31 January 2019

File No: R/2017/23/B and R/2017/22/B  
Our Ref: 2019/048540

**SSD 8875 (Pitt Street North) and SSD 8876 (Pitt Street South) Over Station  
Development Concept Proposals – Response to Submissions**

Figure 2 – Indicative commercial scheme within proposed envelope

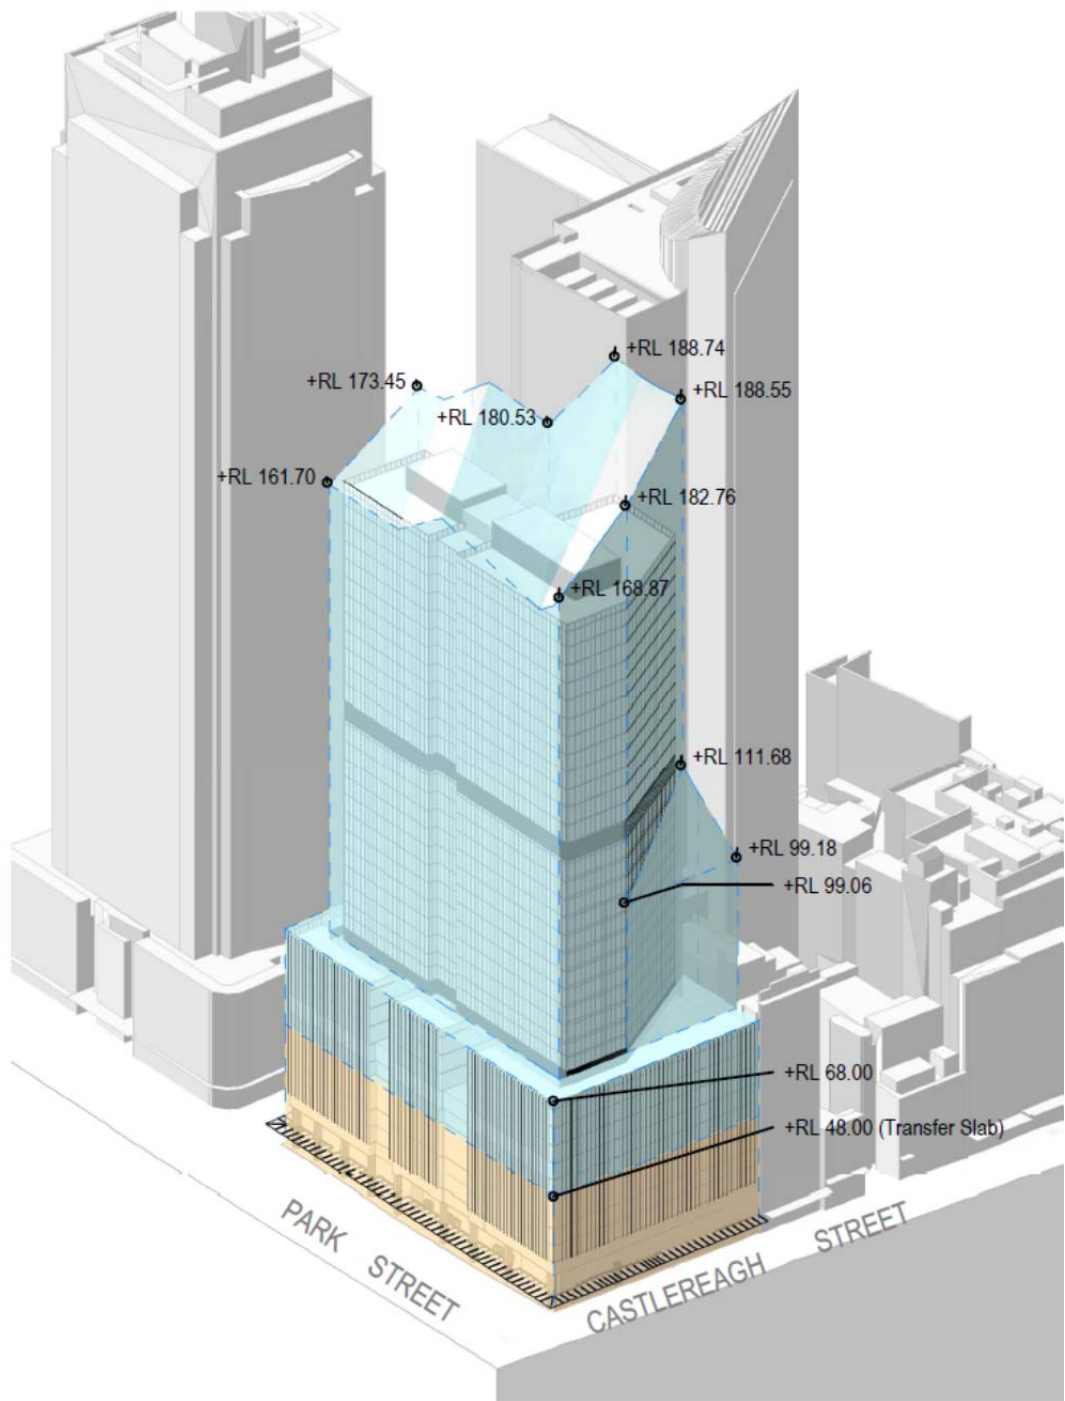
The City's concerns raised in its previous correspondence dated 12 September 2018 in relation to the Pitt Street North site seeking a quantum of GFA still stand and the Clause 4.6 variation requests for either land use option should not be supported. It is inappropriate to approve an amount of GFA at this stage of the planning process.

Given that the proposal for the North site is a *concept* application, the consent authority cannot be satisfied that the proposed development will be in the public interest because it is consistent with the objectives of the particular standard and the objectives for development within the zone in which the development is proposed to be carried out (clause 4.6(4) (a) (ii)). For example, objective (d) of the Gross Floor Area standard is '*to ensure that new development reflects the desired character of the locality in which it is located and minimises adverse impacts on the amenity of that locality*' (emphasis added). A full assessment of amenity impacts from the aspect of the development that contravenes the development standard (not the development as a whole) cannot be properly completed from either two indicative land use proposals or their respective schemes at this stage of a proposal. Accordingly, neither Clause 4.6 variation request can be supported by the consent authority.
